Comment

Site Plan: Please show the exact location of the proposed changes of the drive isle and parking area. The Planner/Project manager will speak to the surface treatment allowable for this use. Please also show the specific areas where vegetative disturbance will occur. If the combined disturbed area exceeds 1 acre a grading plan and ESQCP will be required. A PBMP applicability form will be required, if you disturb greater than or equal to one acre, to determine if additional requirements will be imposed.

Front decorations:

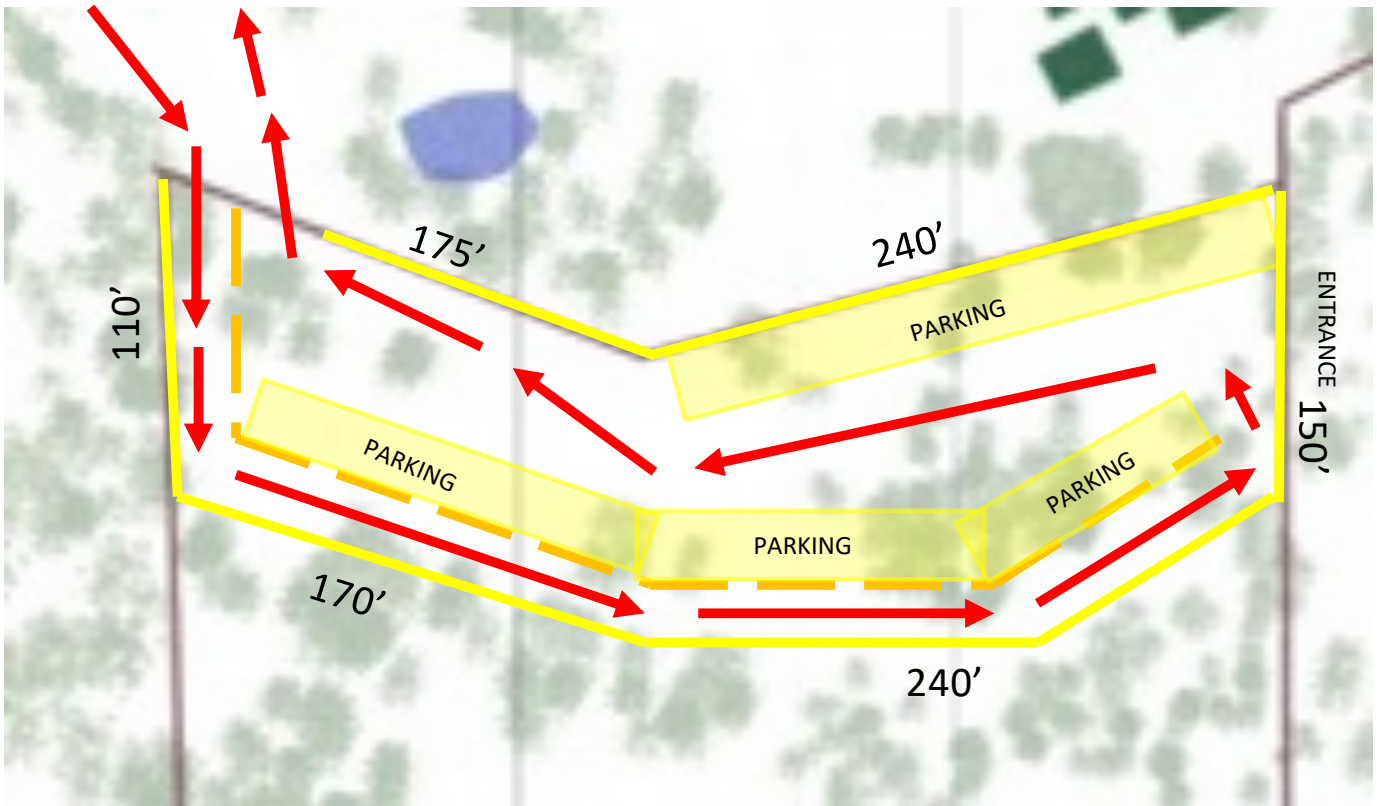
All proposed lighting and or decorations at the entry shall be placed within your property and will not be allowed in the public ROW. These decorations shall not be within the sight line as defined in the Engineering Criteria manual (Please show on plan so that we can assure you that they are in a location that is acceptable. Please show height and width of the decorations).

- New slide to show decorations out front. Provided a rough aerial sketch of the proposed decorations (with labels) at the entrance.

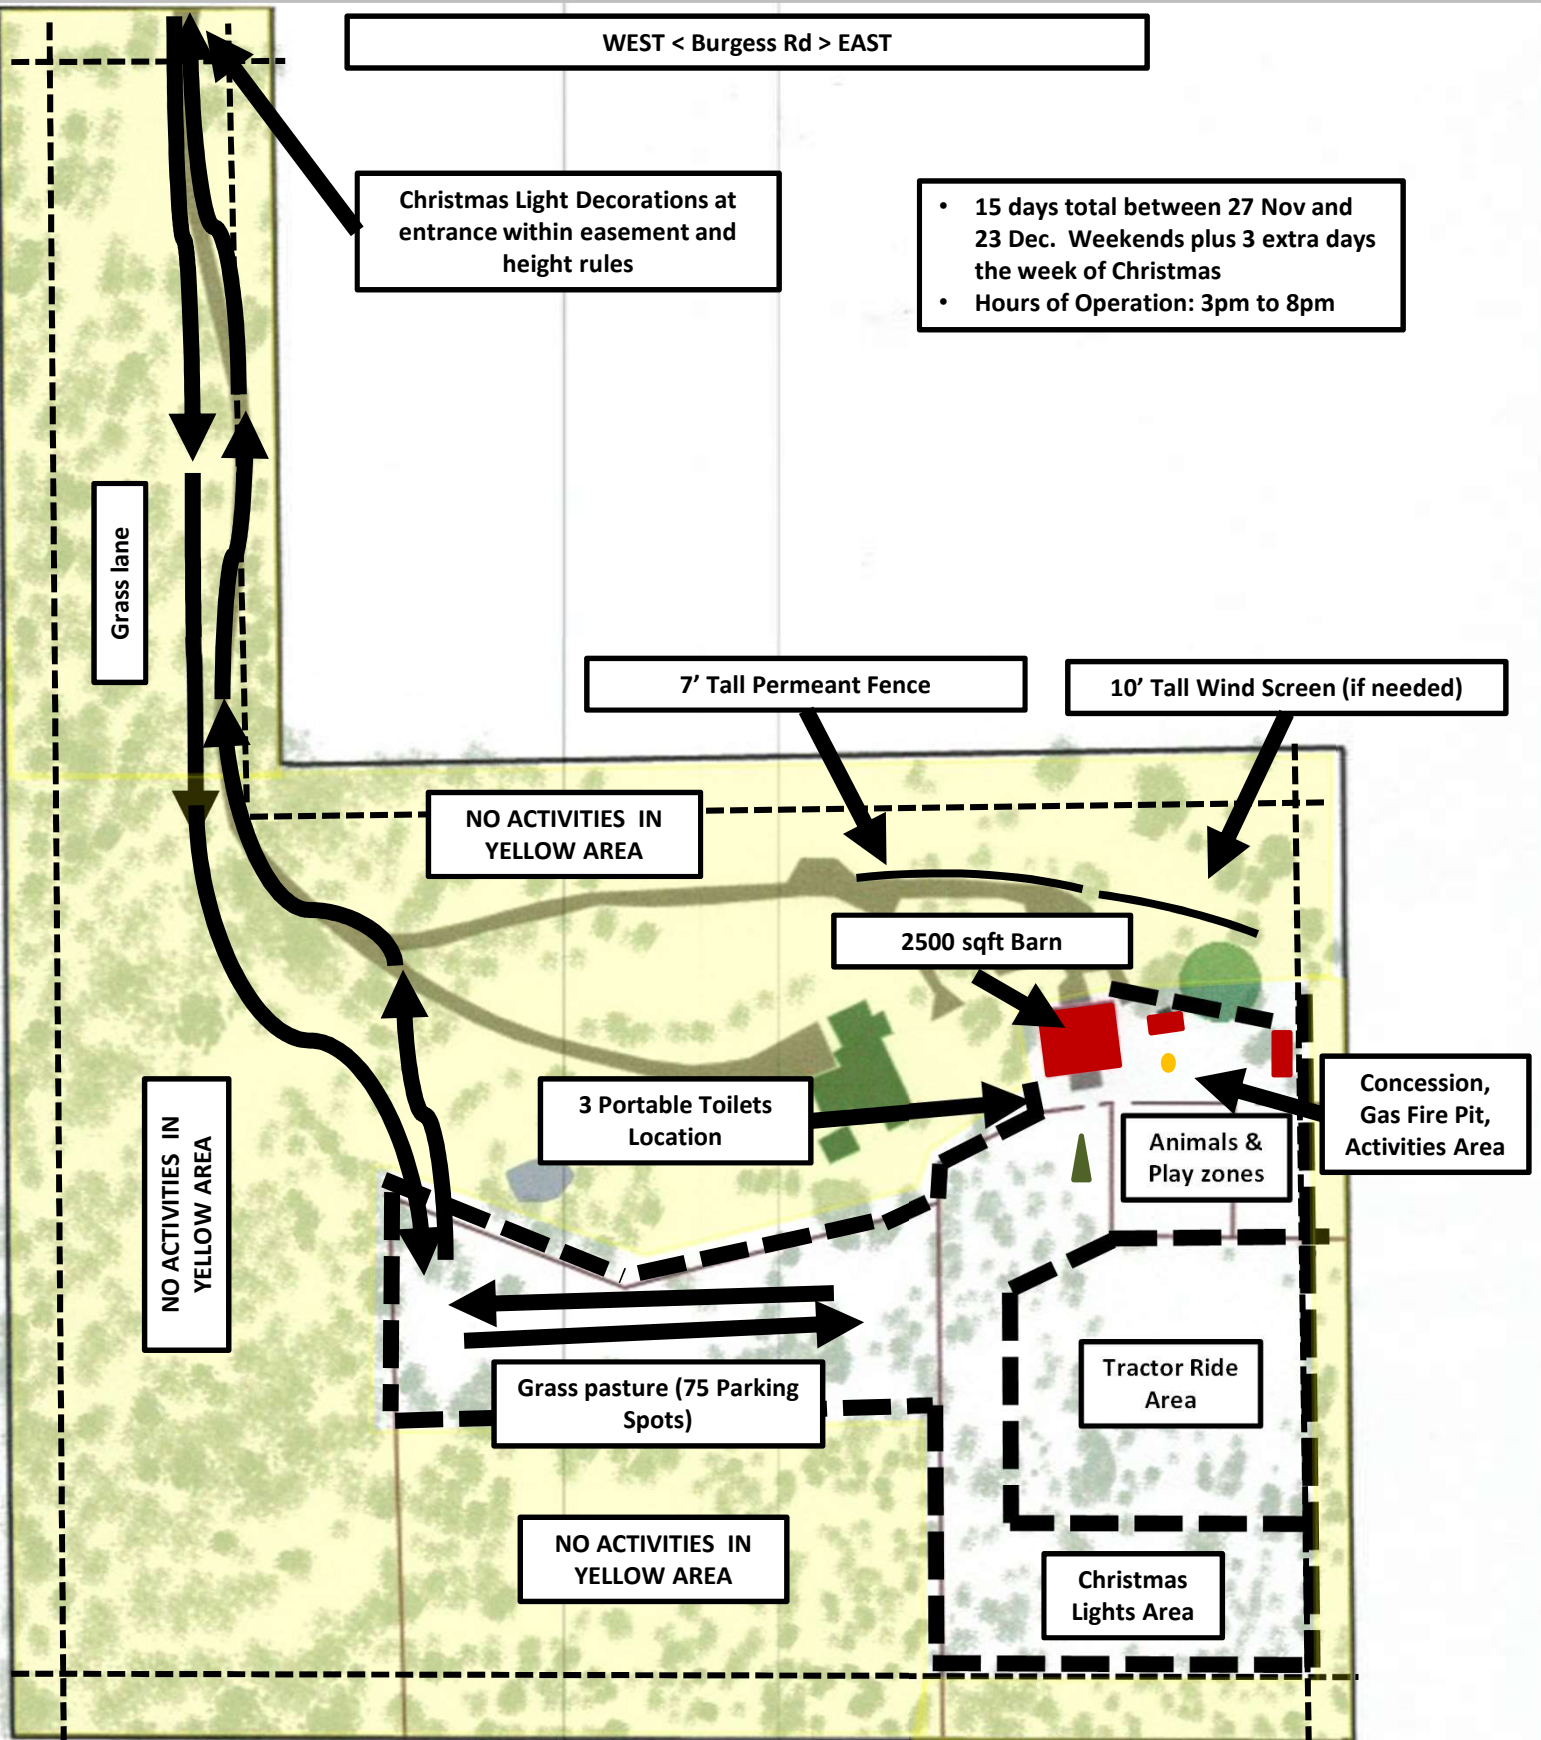
Site Plan - Provide approximate dimensions to the various attractions from the nearest property lines.

For the parking, dimension the length and width of the parking area so we can check to make sure sizing will accomodate parking strips and drive aisle. We know it will not be paved, etc but it still should be sized appropriately for the circulation to work.

Revised map to show:

- Driving isle in and out in RED
- Parking Area dimensions, plus additional detail of flow.
- Designated vegetative disturbance statement added to LOI since 1 acre "Total land disturbance shall be less than one acre and will not negatively affect drainage to adjacent or downstream properties."

Added dimensions from the various attractions from property lines to MAP

Added dimensions of parking length and width of parking area to include a more detailed picture
